Recommendation Report for Planning Permission for Works or Extension to a Dwelling

REF NO: K/23/21/HH

LOCATION: Mimosas
Gorse Avenue
East Preston
BN16 1SF

PROPOSAL: Erection of part 2 storey and single storey rear extension and first floor balcony

Job Number: AR-157 Drawing Number: 04 Revision: Revision

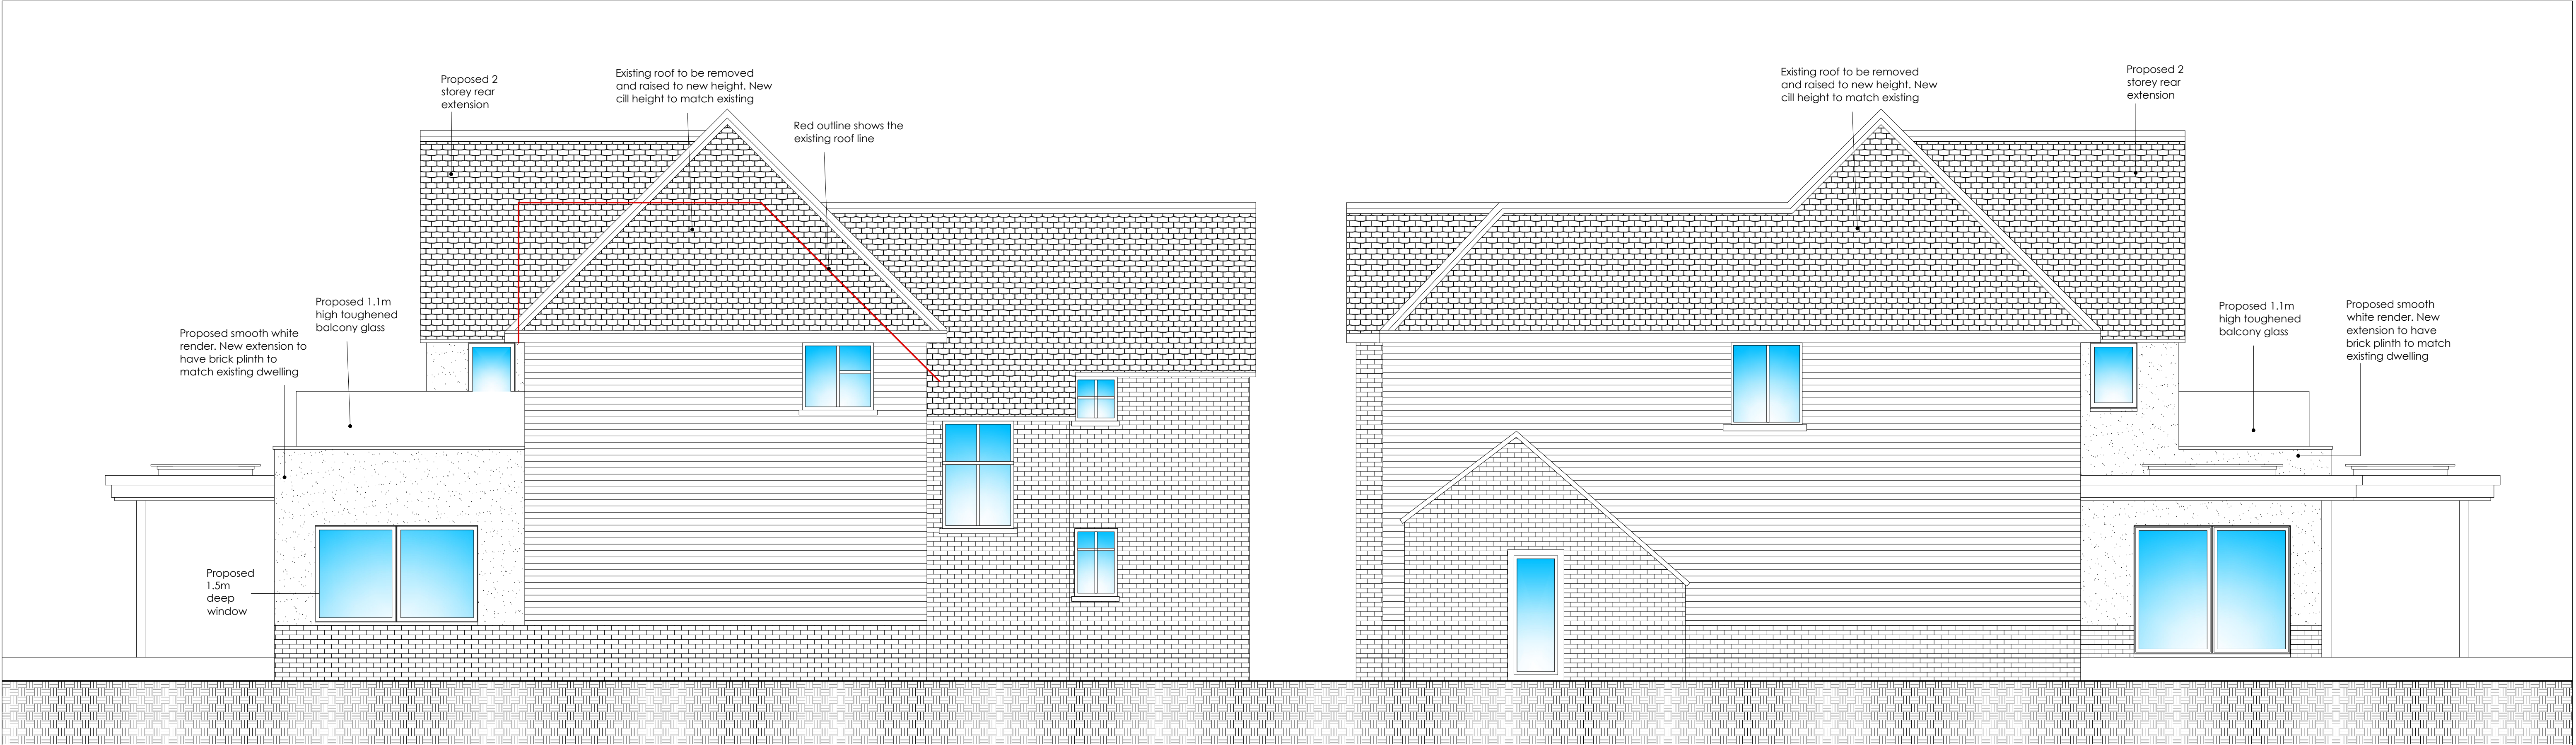
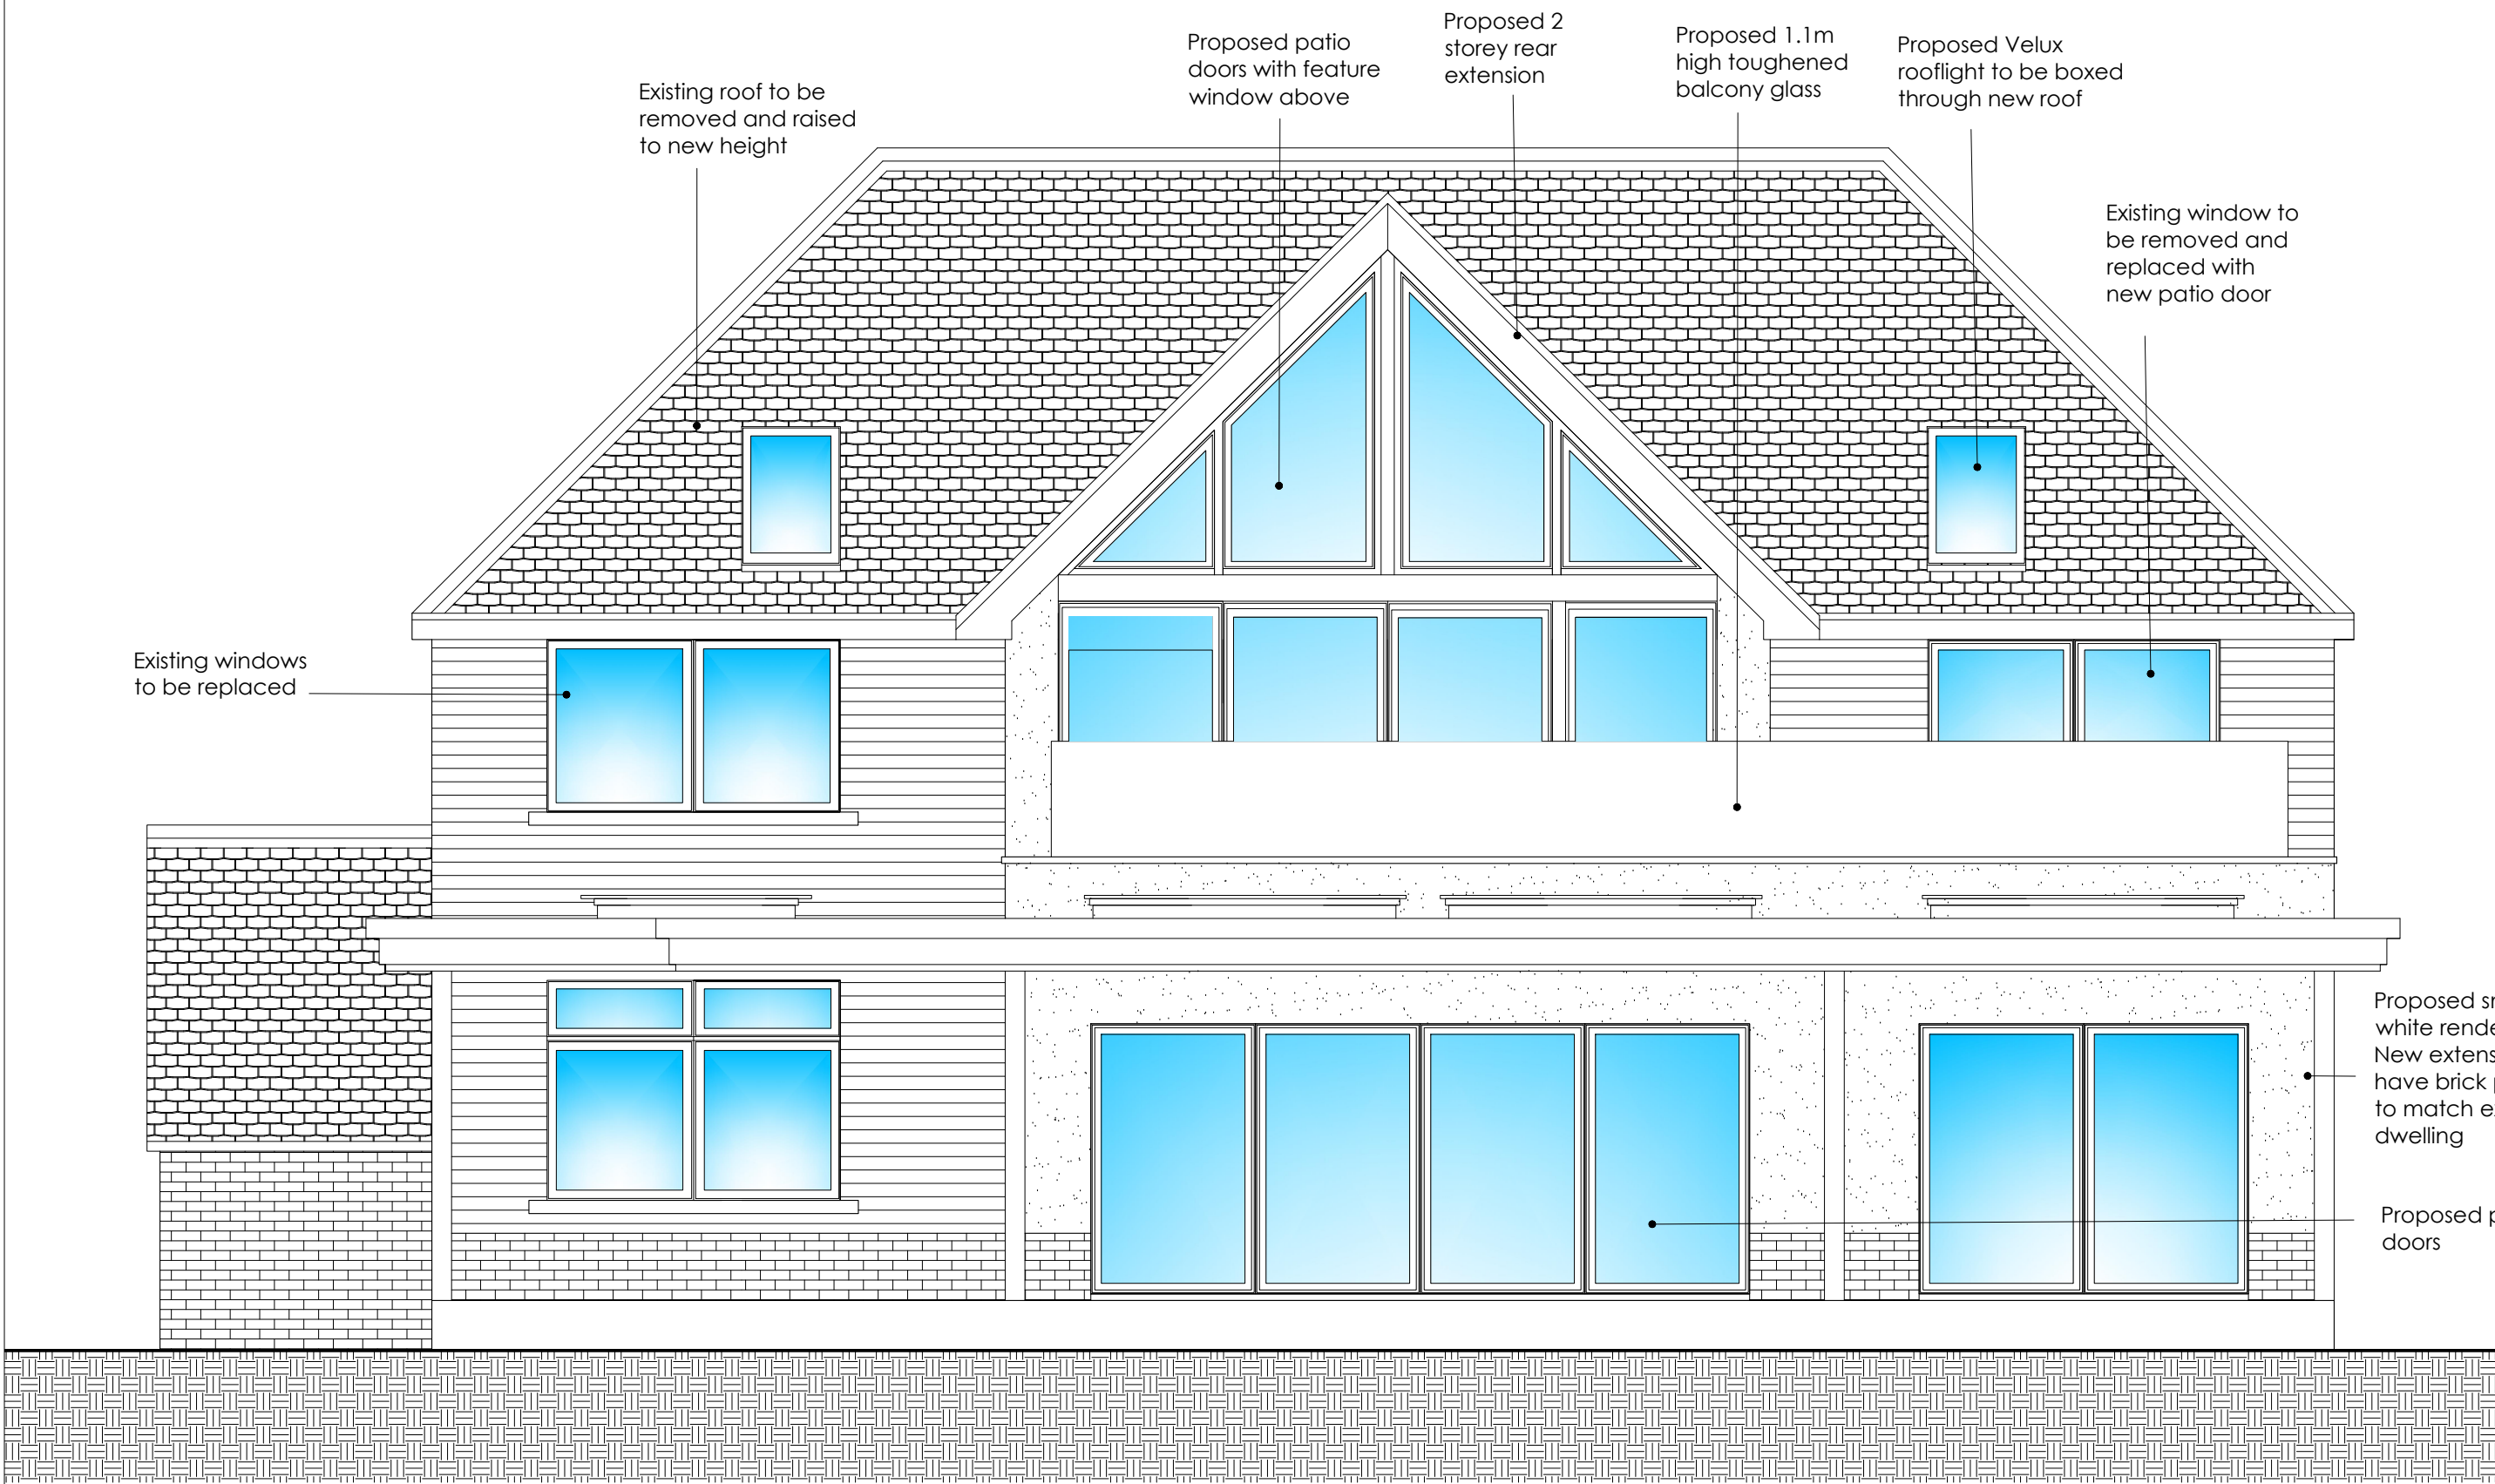
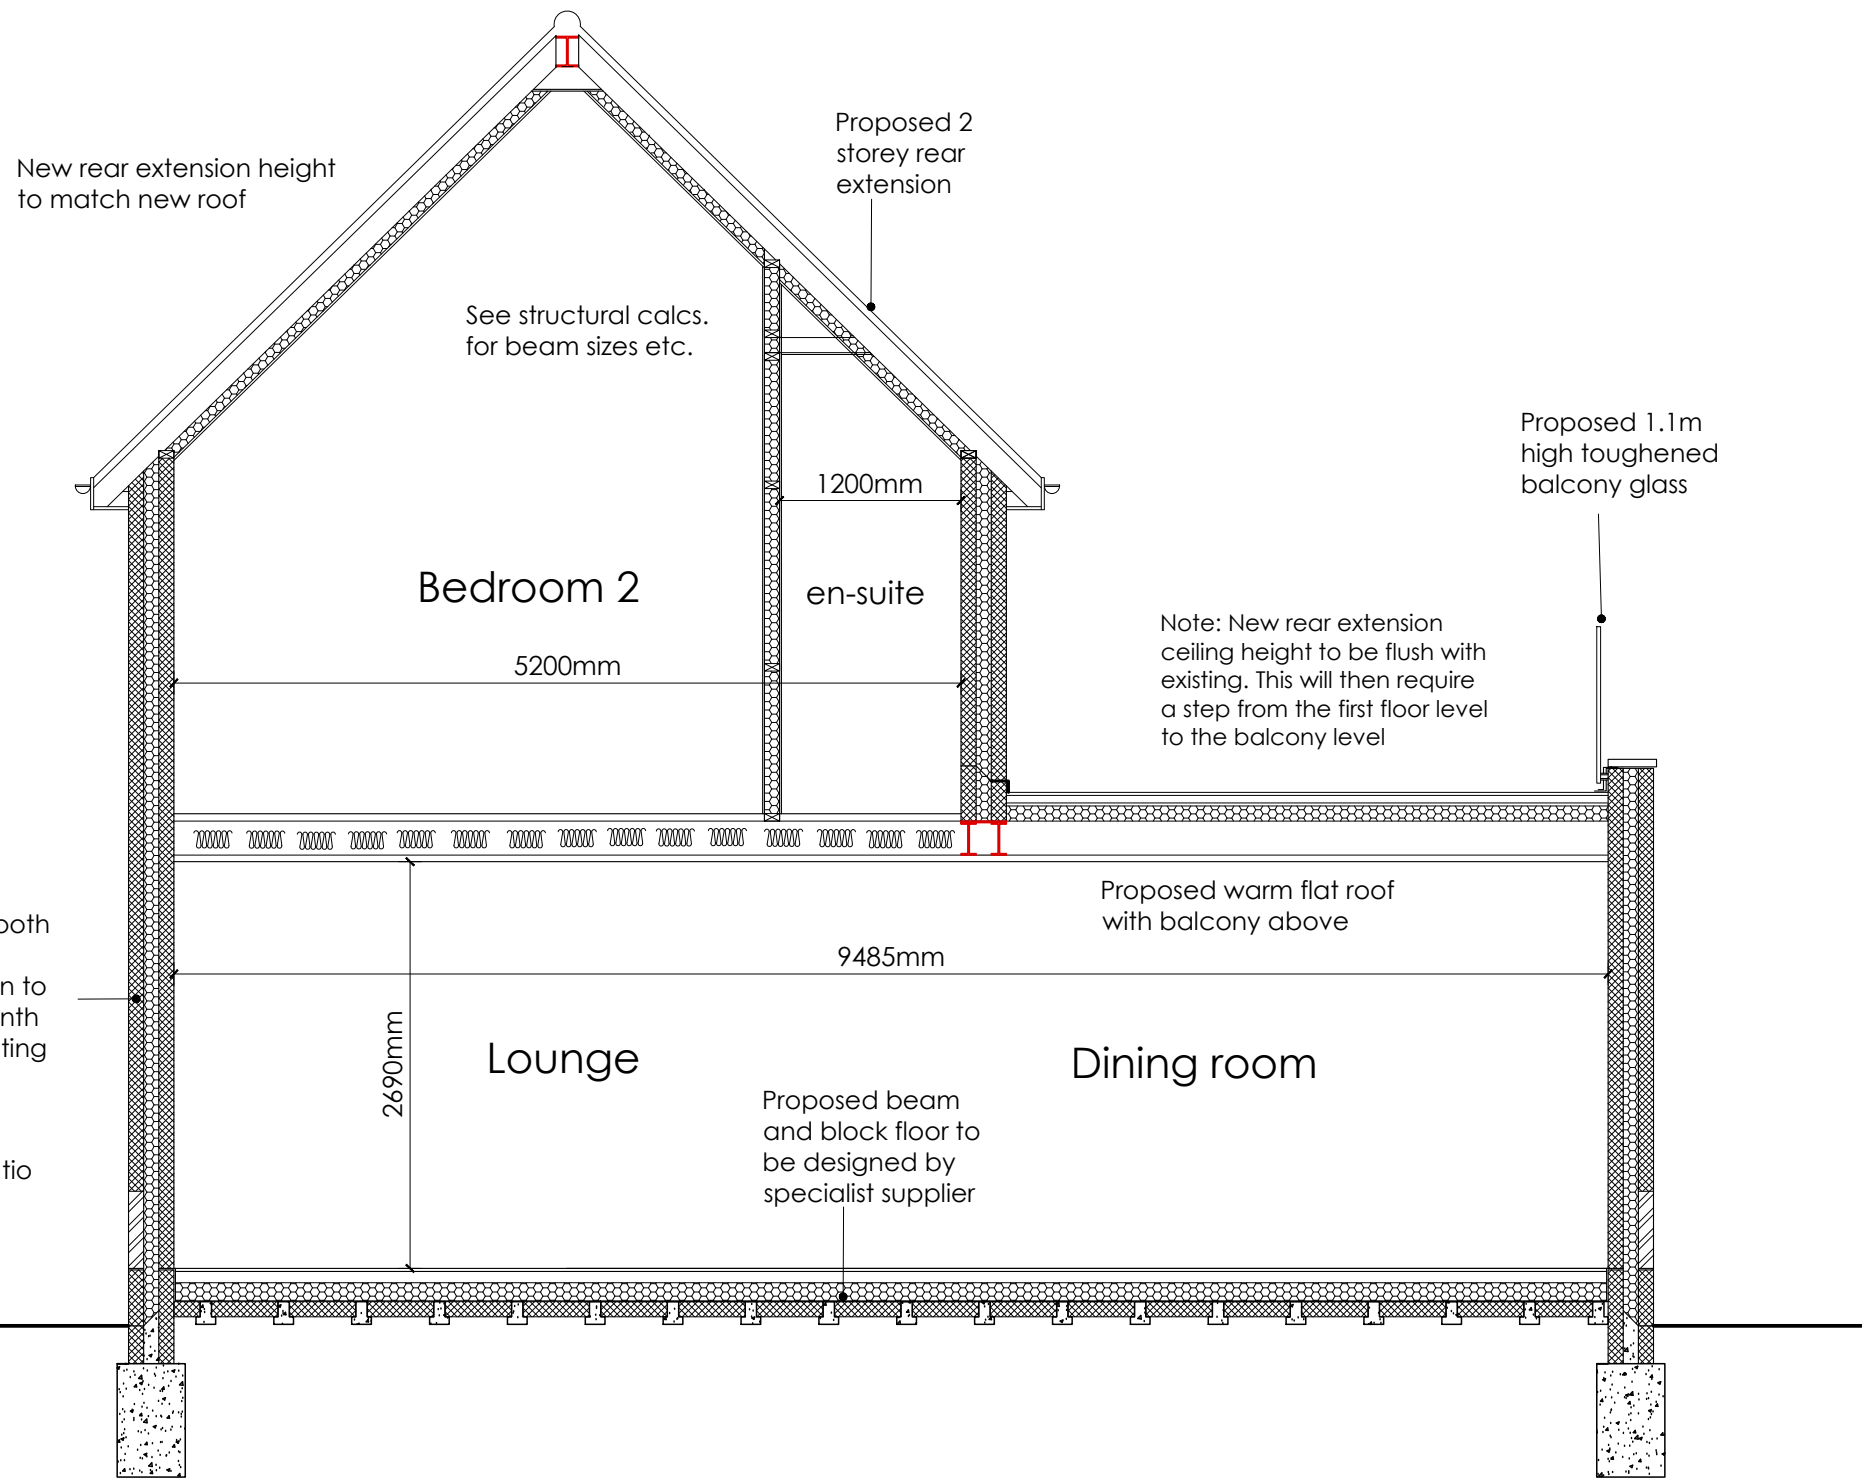
Kingston Parish Council: Objection: ridge height of the extension considerably higher than original, but no heights given for the elevations, only the comment "existing survey was undertaken by others, including heights". rough calculations put it higher by nearly 1 metre (900 mm / 35 inches) to the original roof. - Spring Tide could be overlooked from the new balcony. Kingston Parish Council request, if this application is approved, it must with the provisos: 1. The ridge height is lower or in line with neighbouring properties, and 2. The balcony does not overlook adjacent properties

The two storey aspect due to the raising of the roof height cannot be considered subservient to the host. However due to the increase being of a minor nature it is not to the detriment of the application. There are examples of a variety of heights throughout the estate as such this increase of 1.5m on a spacious plot is not considered to cause a precedent for taller dwellings in the future.

Whilst the height of the property is to be increased which will have some impact on the neighbours the increase is not considered to be demonstrably harmful due to the varying heights of properties within the locality this is due to the existing highest point being 7.25m which will increase to 8.4m with the pitch height increasing by 1.15m. the design of the proposal with a pitched roof allows the scheme to be acceptable, due to the eaves height of the neighbouring properties significantly higher than that of the proposed.
